**Consultation Response from KC,  
Trees**

**2023/91002 Corby, Birkby Road, Birkby, Huddersfield, HD2 2DR**

**Date Responded: 17/05/2023**

**Responding Ref: TPO 46/90**

client  
 Dr I Gilkar  
 project  
 Corby, Birkby Road, Huddersfield, HD2 2DR  
 drawing  
 Existing and Proposed Block Plans

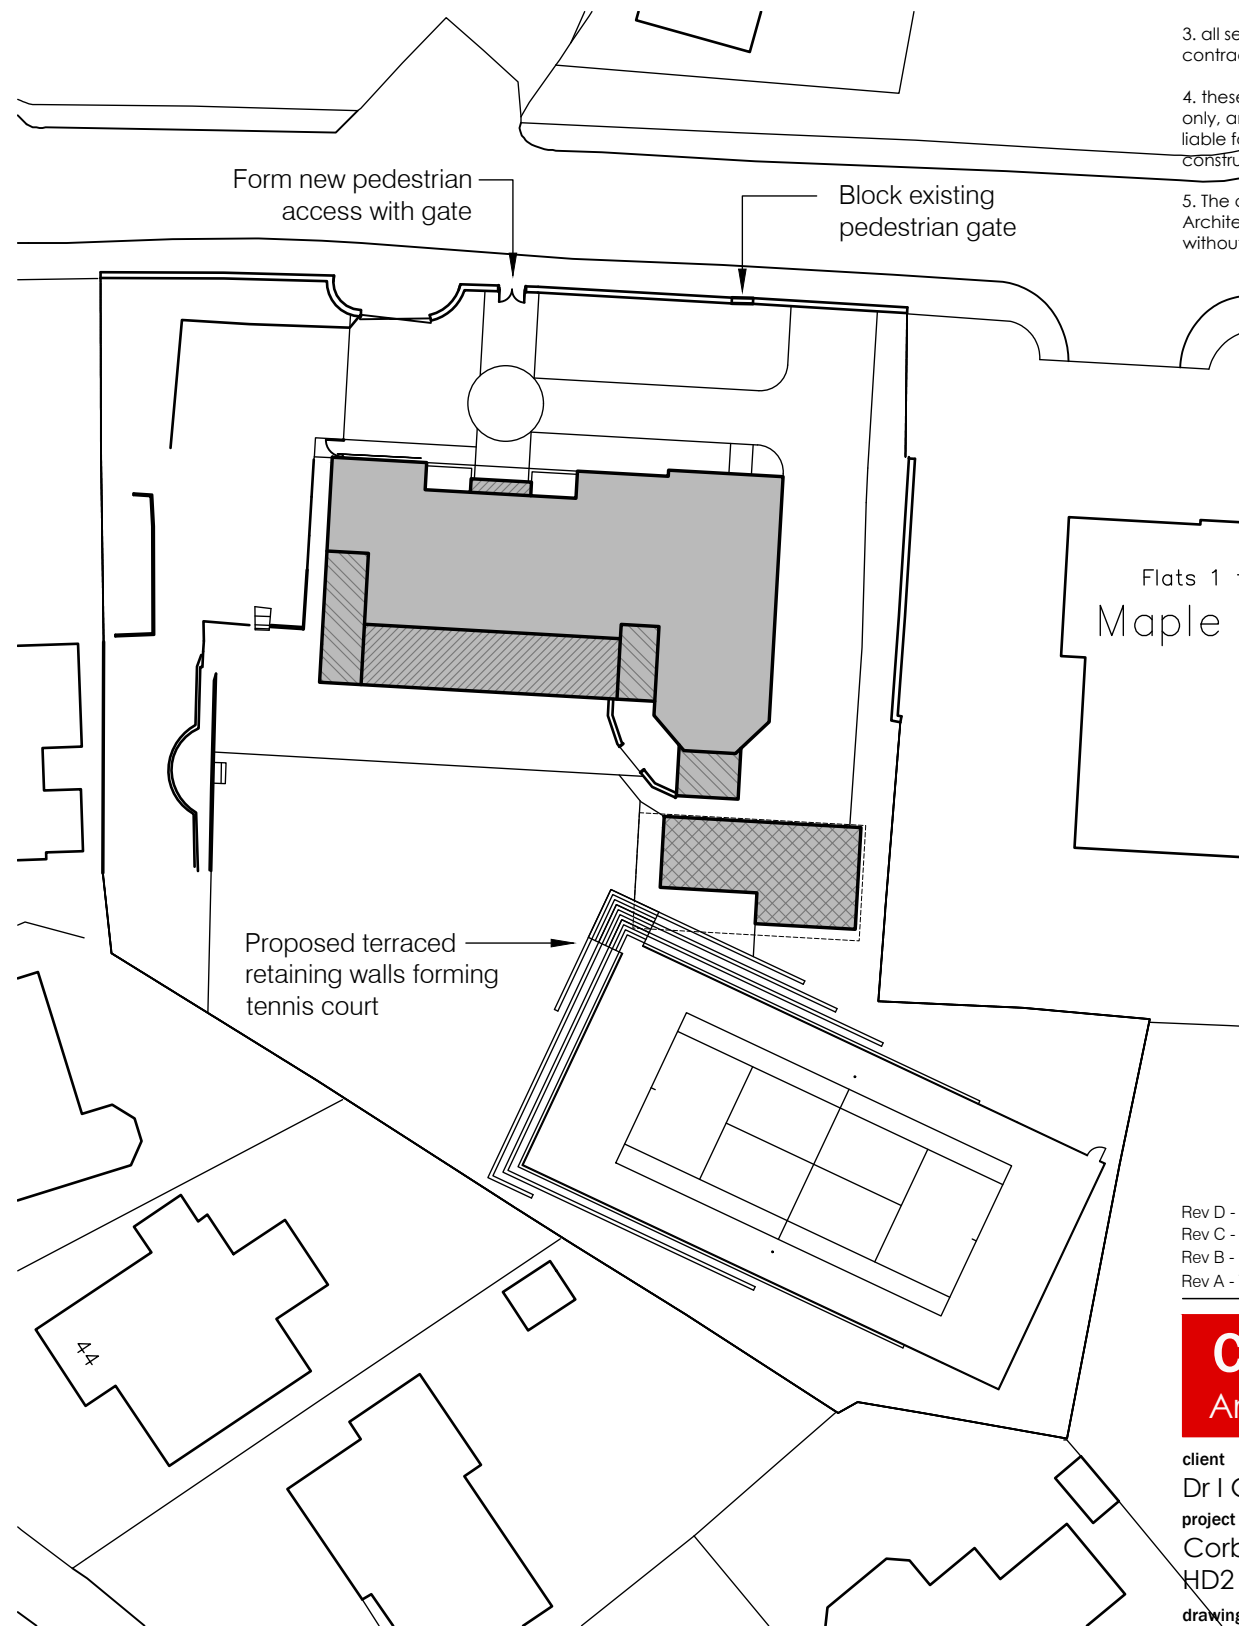
There is a line of trees down the side of the property which are protected by TPO 46/90. Although there has been no specific tree information supplied, looking at the block layout it appears that the proposed garage encroaches into the root protection area of these trees.

Although permission was granted for removal of one of these trees as part of tree work application 2022/92801, it was a condition as part of that permission that a replacement tree was to be planted, as such adequate room for the successful establishment of this tree must be made available.

In order to progress this proposal, we would need to see an arboricultural impact assessment to help understand the impact this proposal could have on existing trees and an arboricultural method statement to show how this work can be done without causing harm to trees or their roots. If the access needed to facilitate this work is to be the driveway running alongside these trees how will this be done without damage being caused.
